# KITTITAS COUNTY

### MEMORANDUM

**TO:** All Staff  
**FROM:** Justin Turnbull, County Surveyor  
**DATE:** November 14, 2022  
**SUBJECT:** BL-22-00021 Jones & Smith – Survey Review

# RECORD OF SURVEY

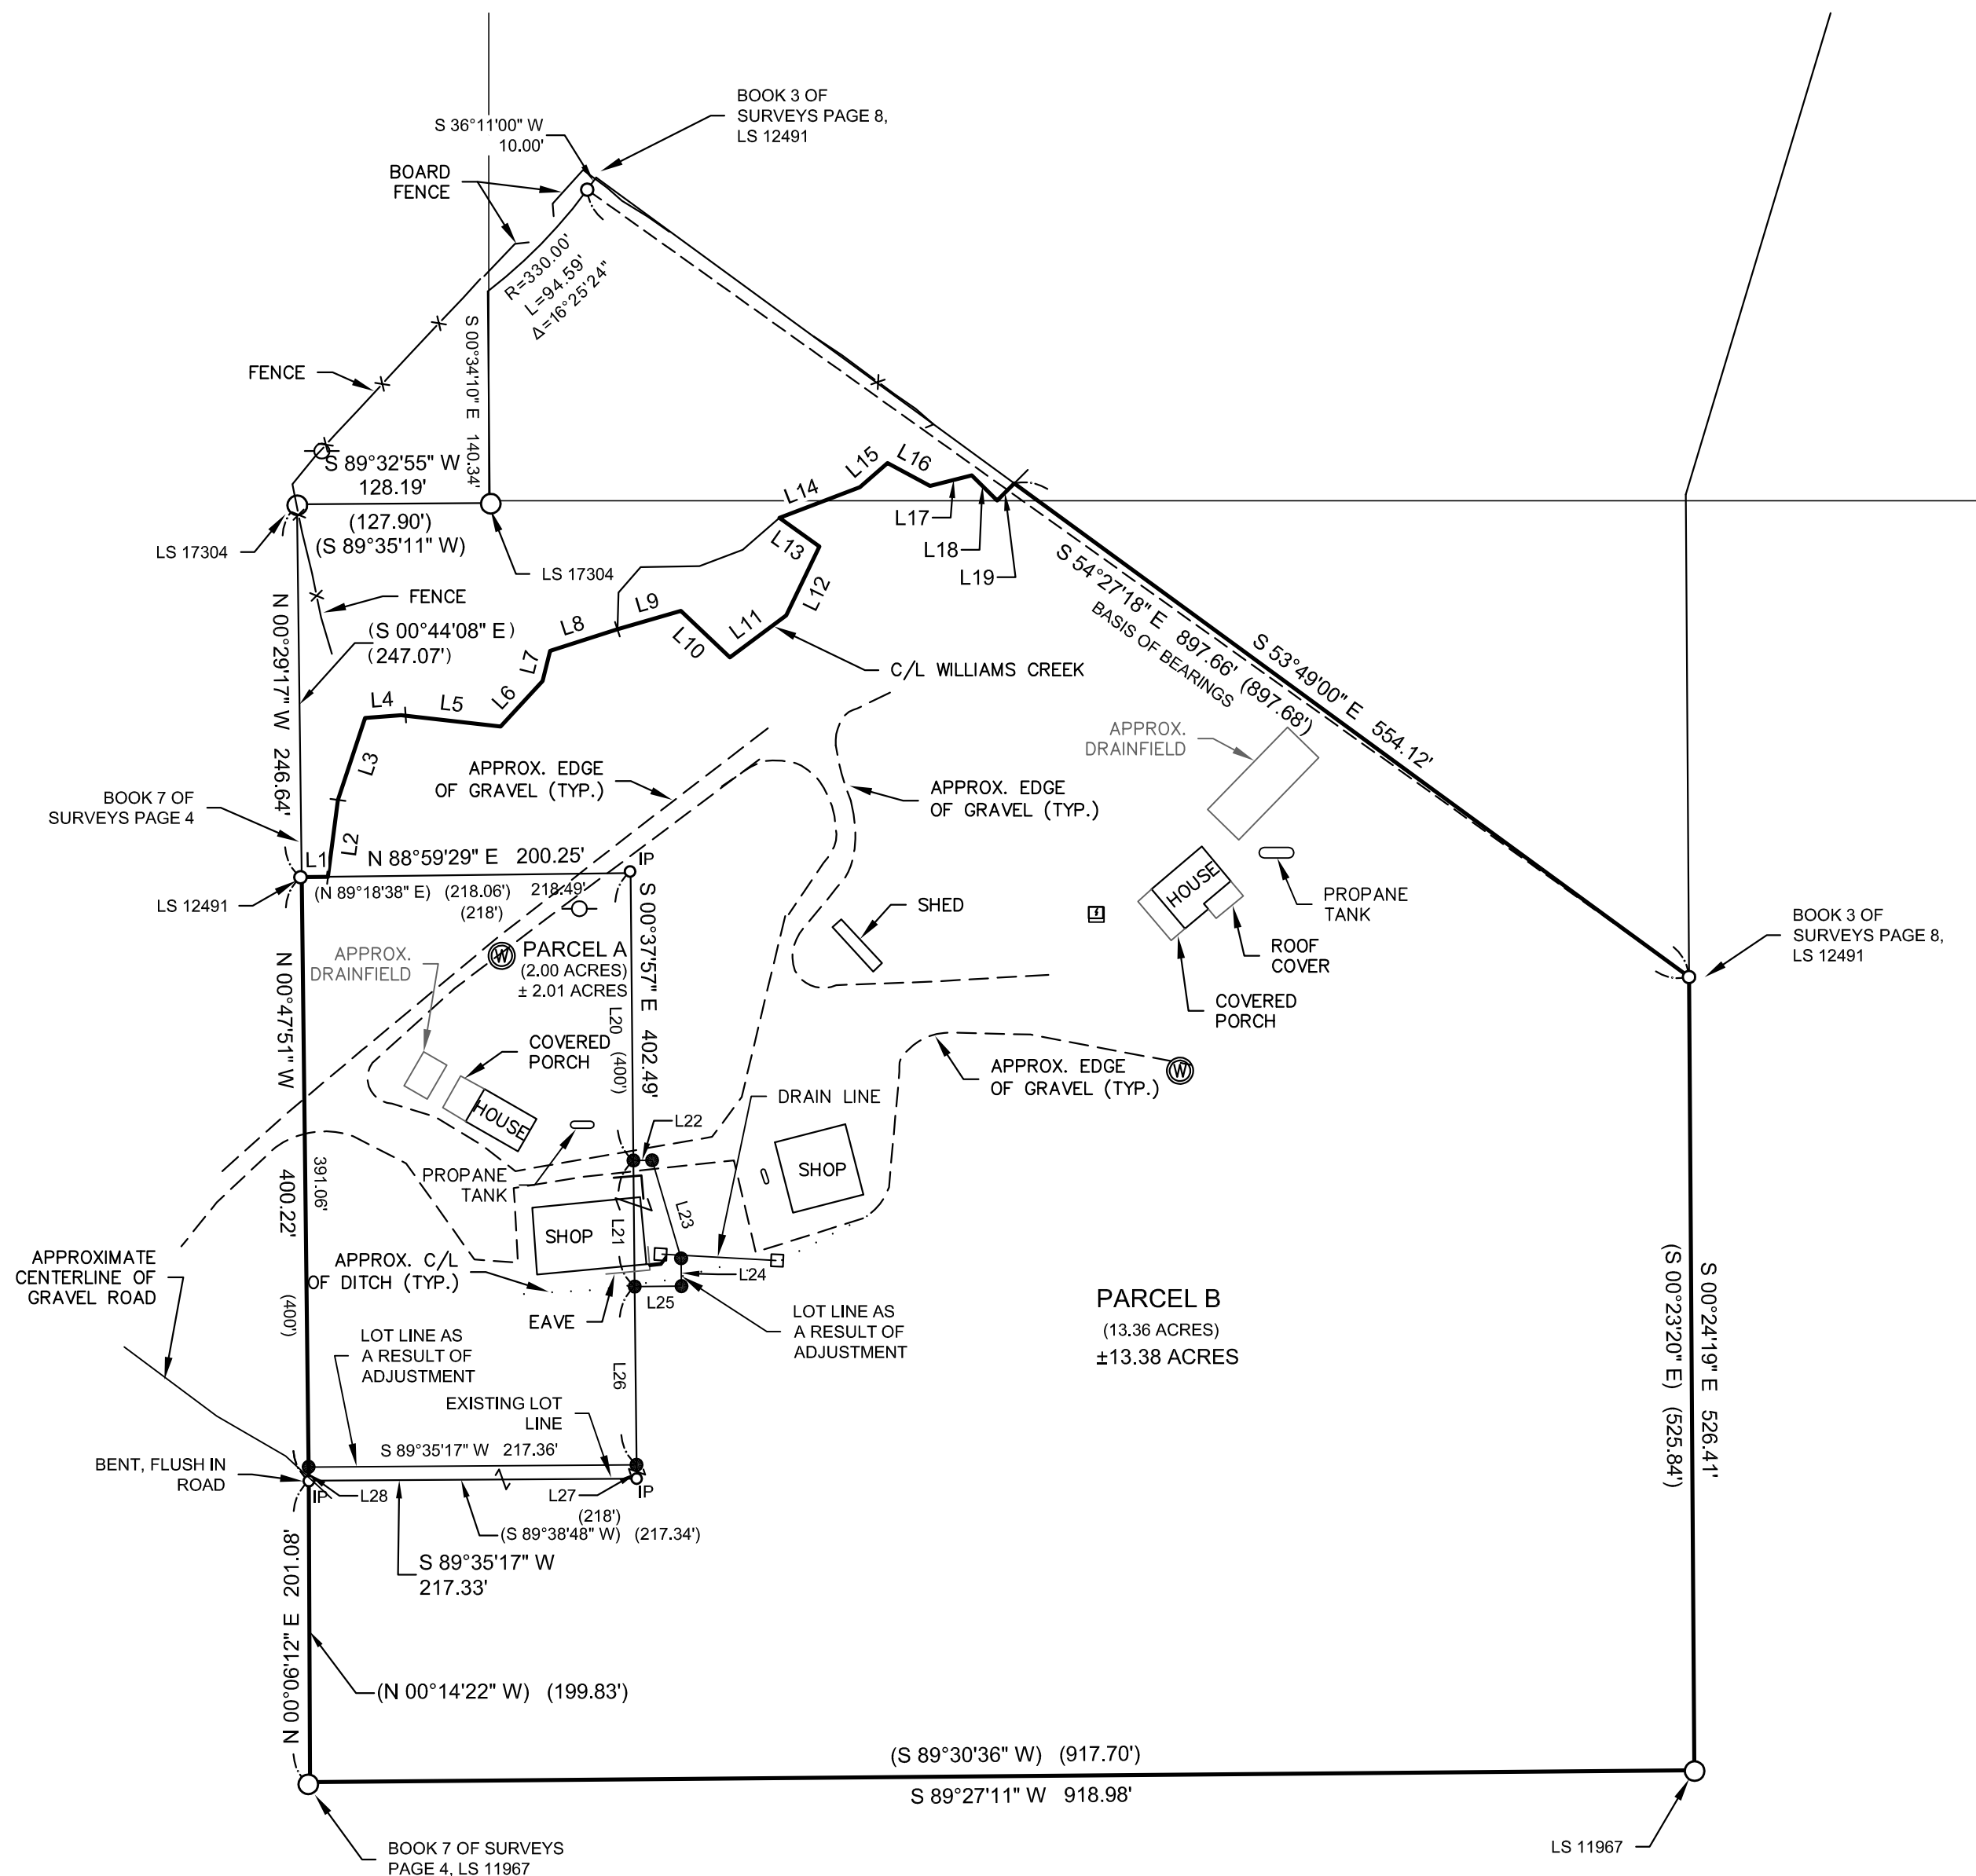
1. The North line of Parcel A has a distance measurement obscured by crossing linework.
2. Please include labels for Cougar Gulch Rd. and Boulder Creek Rd. as the width and position is not clear from public record, applicant is not required to show width, ownership, or a retraceable position.
